KIRKLEES METROPOLITAN COUNCIL INVESTMENT & REGENERATION SERVICE

DELEGATED DECISION TO DETERMINE APPLICATIONS FOR LISTED BUILDING CONSENT

Reference No:	2021/65/93688/W
Site Address:	75, New North Road, Edgerton, Huddersfield, HD1 5ND
Description:	Listed Building Consent for internal and external alterations, installation of rear disabled access ramp (within a Conservation Area)
Recommending Officer:	John Holmes

DECISION – Grant Listed Building Consent

Drawing Title
Proposed Site Plan

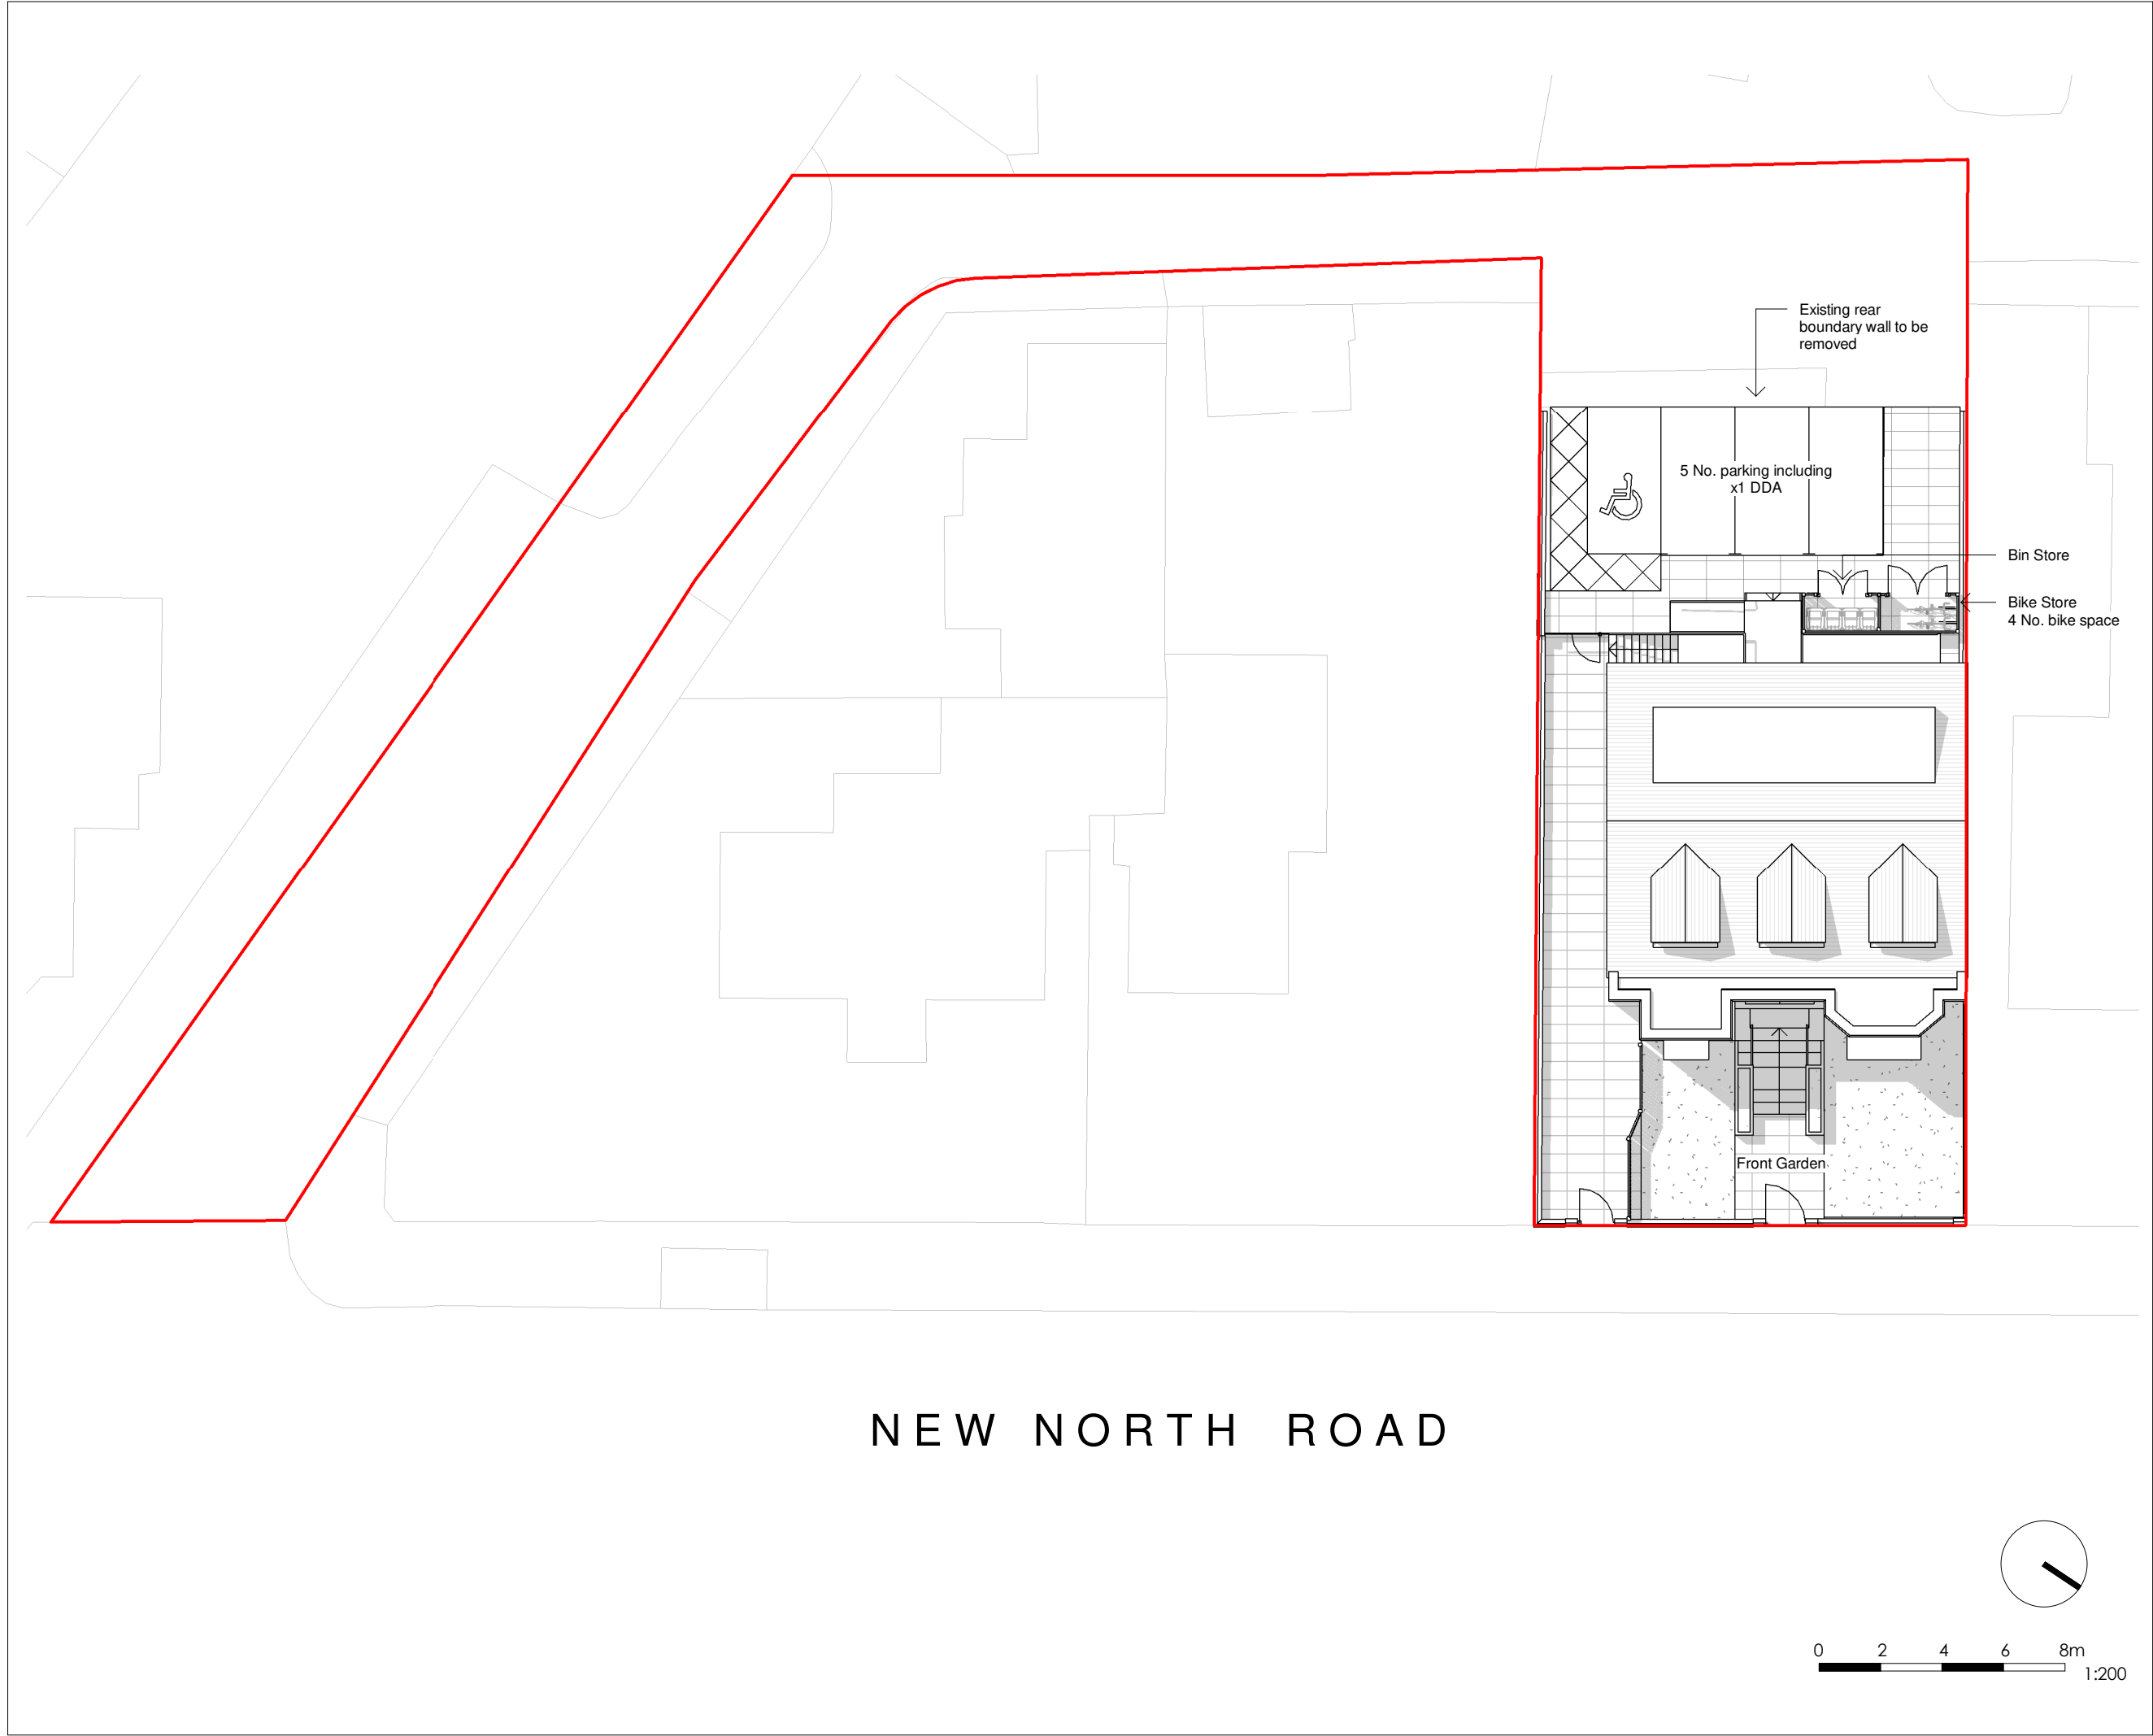
which reduced the extent of alterations to the listed building and amended the bin / cycle storage arrangements.

Proposed Ground Floor Plan

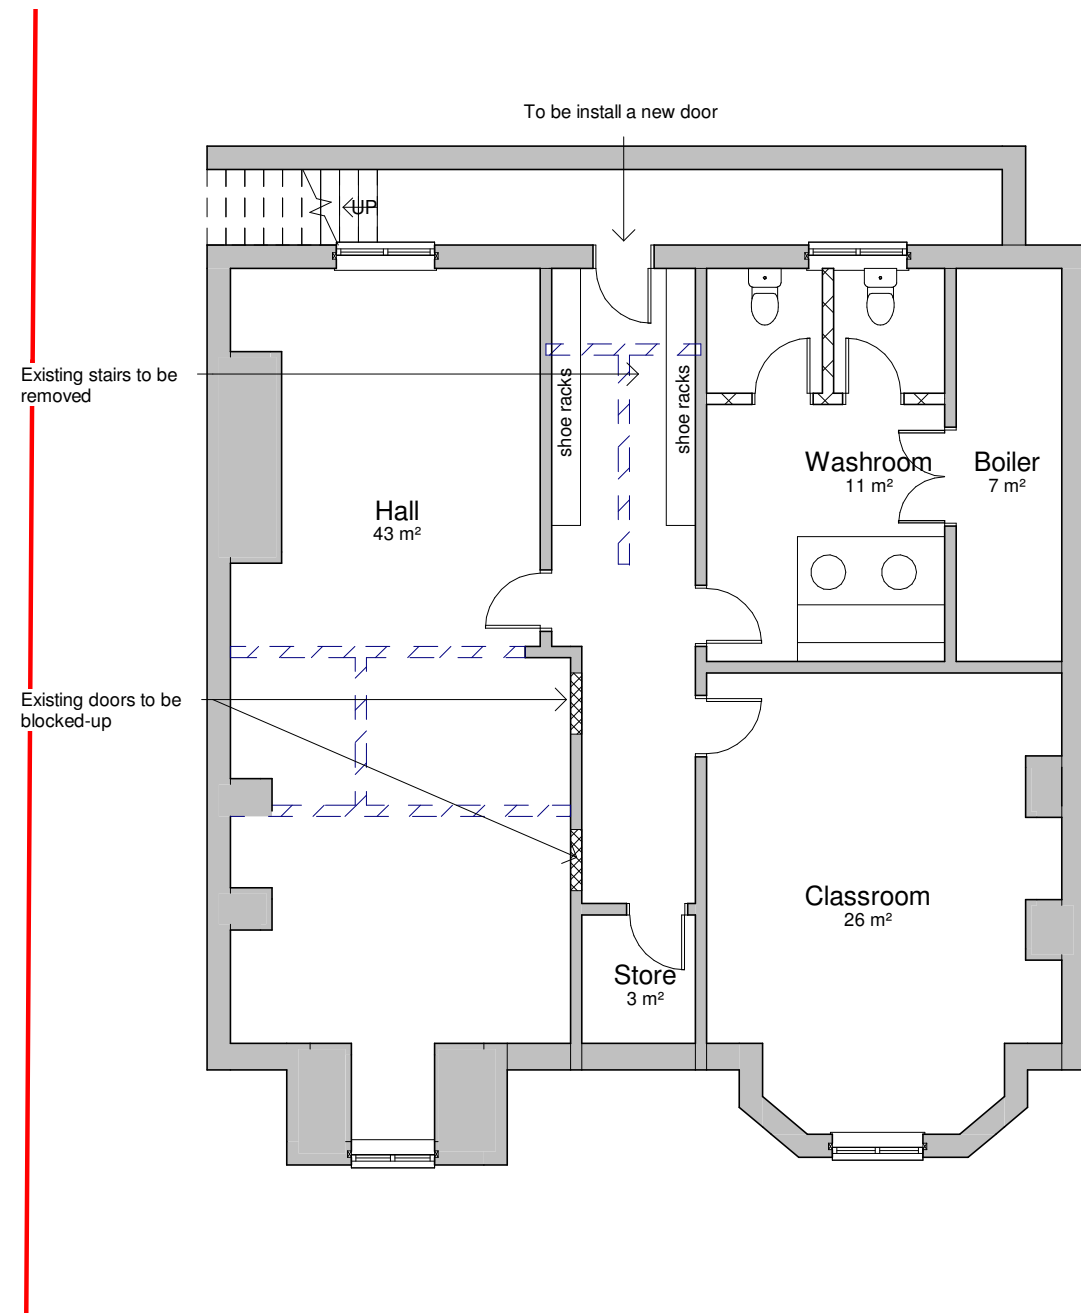
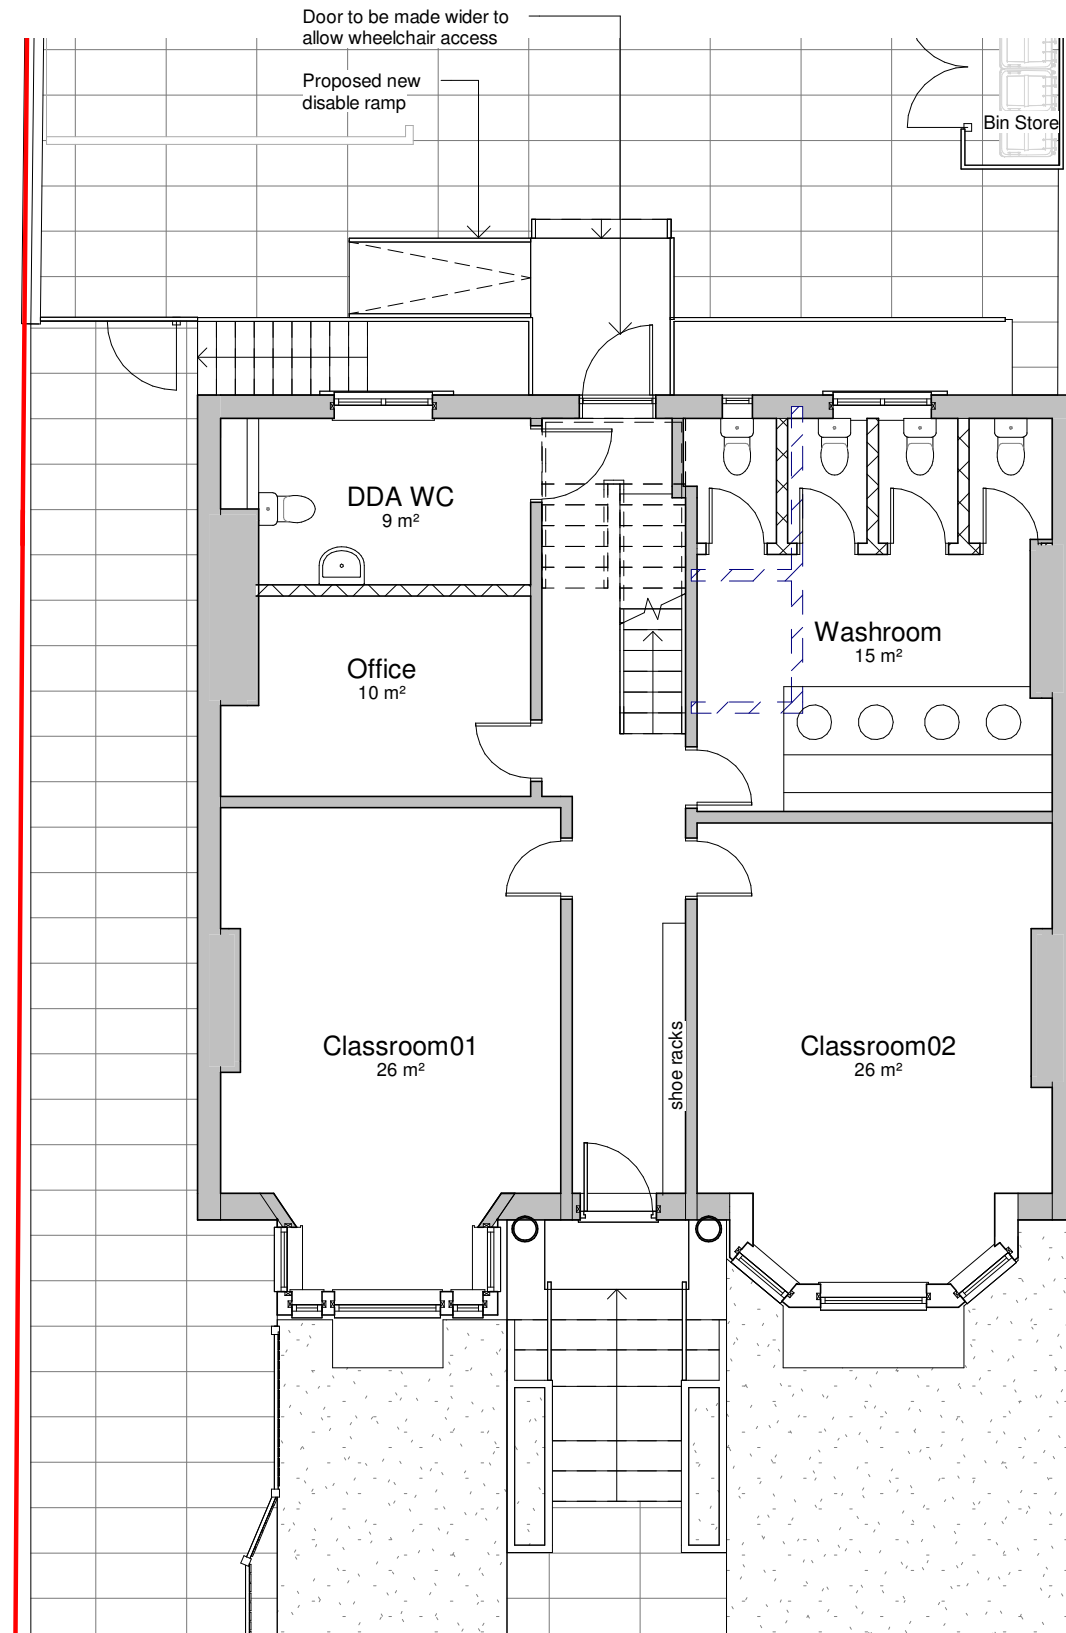
With regard to internal alterations. The Conservation Team confirm that the significance of the basement is considered to be low and the reconfiguration of this space whilst leading to low level of harm, is acceptable. Further justification has been submitted, explaining that the existing staircase is not historic and the narrow hallway to the external entrance could create a bottleneck in the event of a fire. The Conservation Team consider the further justification is acceptable in relation to that alteration.

The application has been amended to reduce the extent of further internal demolition, with the sufficient retention of internal walls to the rear for the historic floorplan to be understood. The loss of the central front room in its entirety is still proposed, and the Conservation Team recommend that the

2. All beams supporting the original walls which are removed shall be boxed in below the ceiling height.

Drawing Title
Proposed West & South Elevations

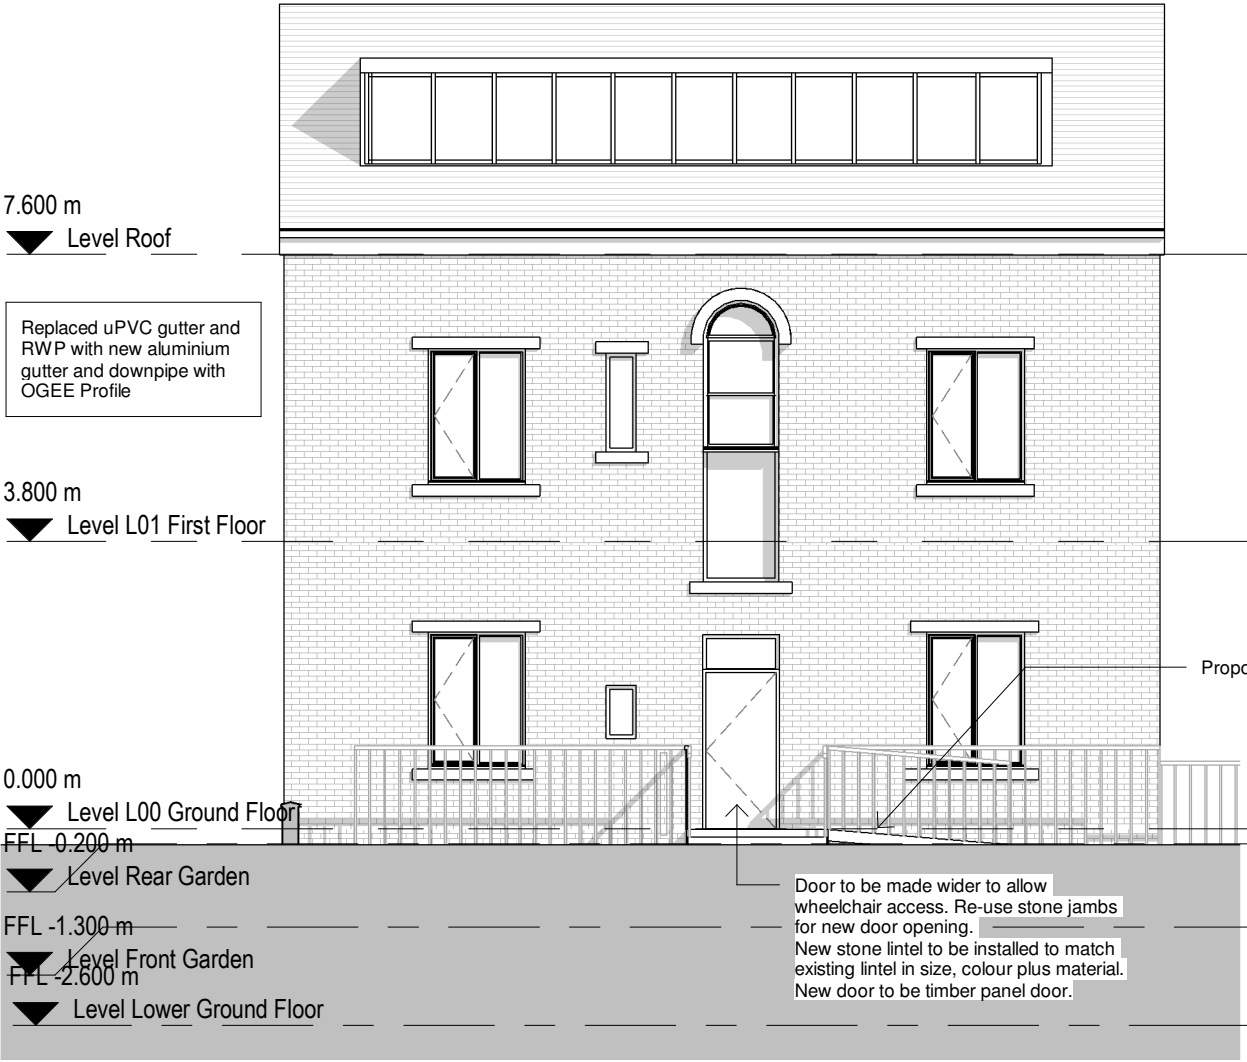
Within their further response the Conservation Team confirm that externally the proposed changes are considered to be minimal and generally acceptable, subject to new aluminium downpipes having a round section, and gutters having an ogee section. Use of existing stone jambs for works to widen the doorway are recommended. If a new lintel is required they advise that this should be in matching stone type, tooling, bedding and colour. They consider the timber panelled door acceptable.

CCTV cameras and external lights are proposed to replace the existing units. Small units with black housings are proposed. The Conservation Team consider these to be fixed in unobtrusive locations such as under the eaves or adjacent to downpipes, with fixings through mortar joints and not drilled into the masonry. They advise this is an enhancement on the existing and note the inclusion of such measures is considered necessary following recommendations in the KC Crime Prevention response.
